Polly Harris-Gorf
Principal Planning Officer
South Holland District Council
Council Offices
Priority Road
Spalding
PE11 2XE

14 June 2021

RE: Reserved Matters application ref: H14-0165-21 – Response to outstanding issues

Drawing Number:	Rev:
487-SK-05	D

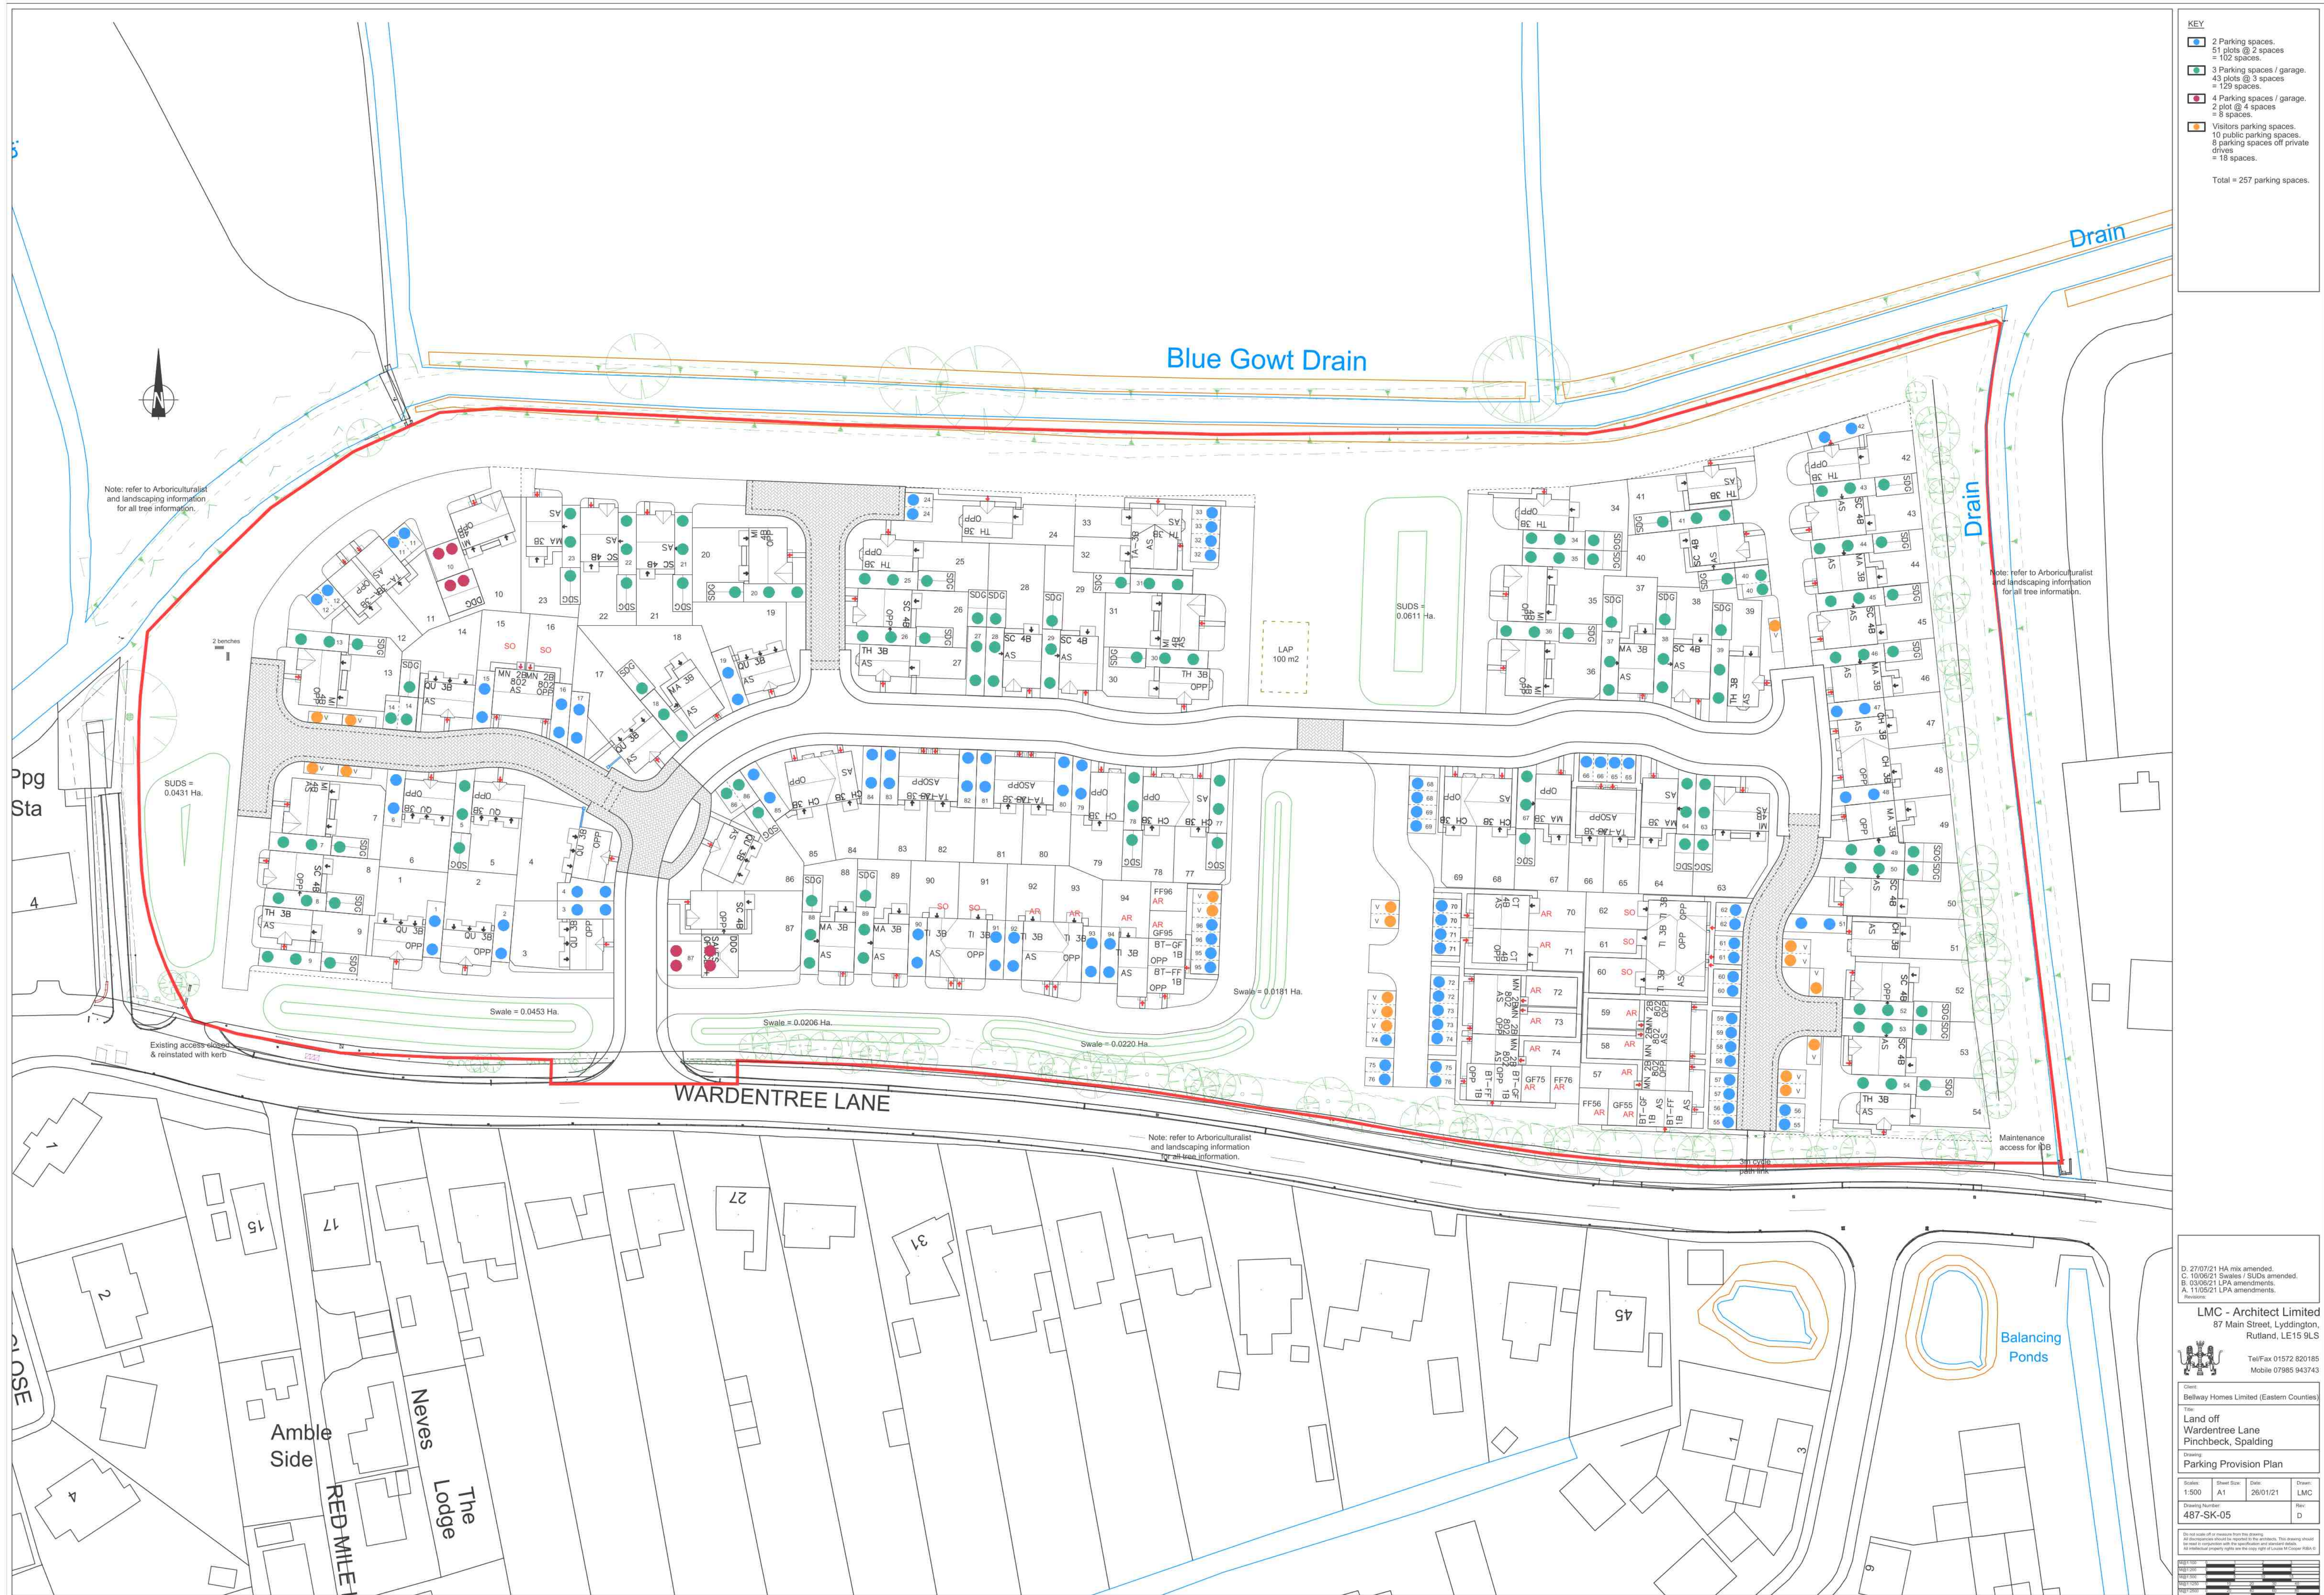
Parking provisions – all to be on plot. Look at plots 68 to 76, also parking for plot 55 seems to be outsider plot 54. Plot 57 parking is split.

We have reviewed the car parking arrangement in the location identified. The car parking spaces for plots 68-69 have been amended so that they are located adjacent to the dwellings and more convenient to access (see Parking Provision Plan (487-SK-05 rev B). With regards to the maisonette units, it is more difficult to achieve on plot parking due to the nature of the layout of these units. We believe that the split parking; with at least one parking space in front of the plot is a suitable compromise. Also, the maisonette units (plots 55-56 and 75-76) and plots 57 and 74 are located at the end of the respective driveways which would avoid any conflict with other car parking spaces.

The car parking spaces for plots 55-56 which are located on the over side of the driveway are separated from plot 54 by a 2 metre wide verge which will have a tree and a driveway. The spaces would be a sufficient distance from plot 54 so as not to appear as part of plot 54. Additional landscape details could be provided in front of the spaces (and visitors) such as a hedge or knell rail fence to provide separation, if that would assist.

However, we are proposing a 1.2 metre 'countryside style' timber post and rail fence along the open space in front of the car parking spaces for plots 68 to 76. Additional planting and hedgerow will also be provided to soften view from the open space and enhance the outlook from the dwellings facing over the open space.

Drawing Number:
487-SK-07

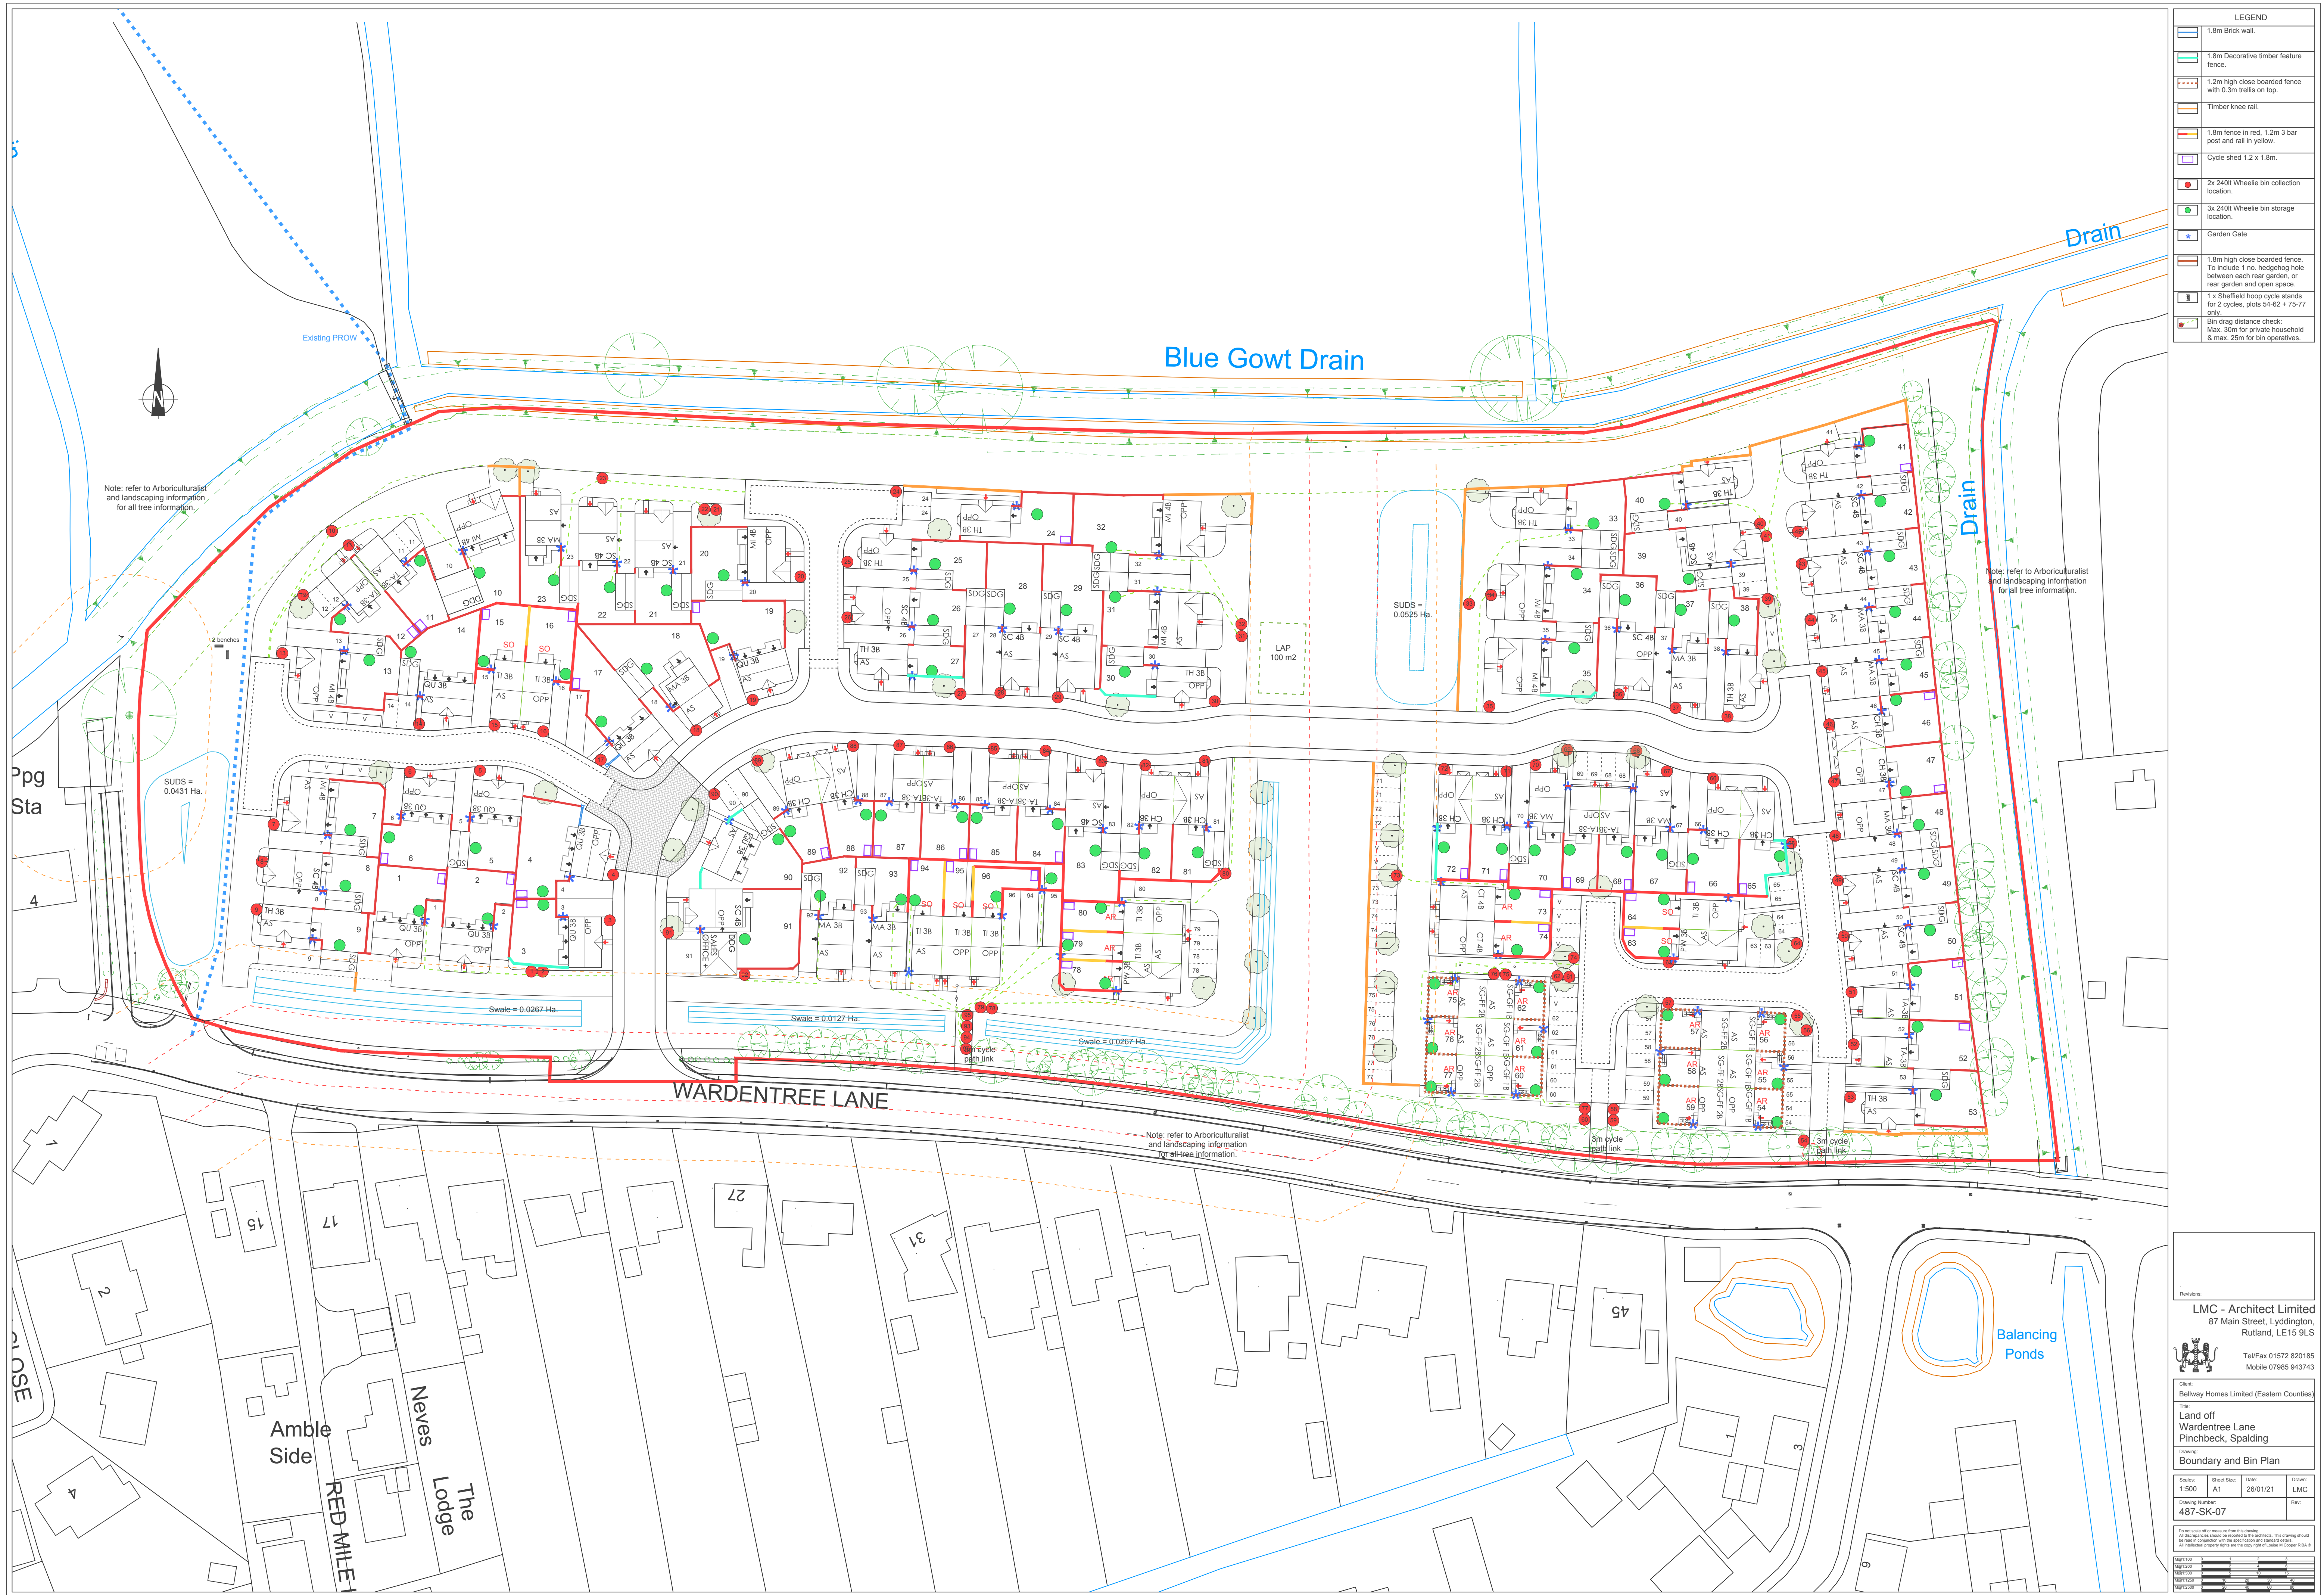
Please explain the boundary and bins plan – SHDC operatives will not enter on to private drives/unadopted highway. SHDC does not have wheelie bins. Building Control - Private Drives to take the weight of a 18t Fire Appliance and properties should not have to carry refuse any more than 30m.

The Boundary and Refuse plan (487-SK-07 rev B) has been updated to reflect the fact that SHDC householders do not benefit from wheelie bins. Each dwelling will have a refuse sack collection point in front or as close as possible to their property to enable collection. A location of the storage of refuse is also proposed in the rear gardens. No future occupier would need to carry refuse more than 30 metres. The drag distances are shown on the Boundary and Refuse plan. The main access and secondary drives have been tracked to ensure refuse collection vehicles are able to access and manoeuvre through and out of them in forward gear.

The garage dimensions are in accordance with the SELLP Appendix 6: Parking Standards so they can count as parking space (2.6 metre x 5.6 metre). However, the garages will not meet the requirements to comply with cycle parking provision. Therefore, Bellway have proposed to provide lockage sheds (1.2 metre x 1.8 metres) in each of the gardens. The locations of the sheds are shown on the Boundary and Refuse plan.
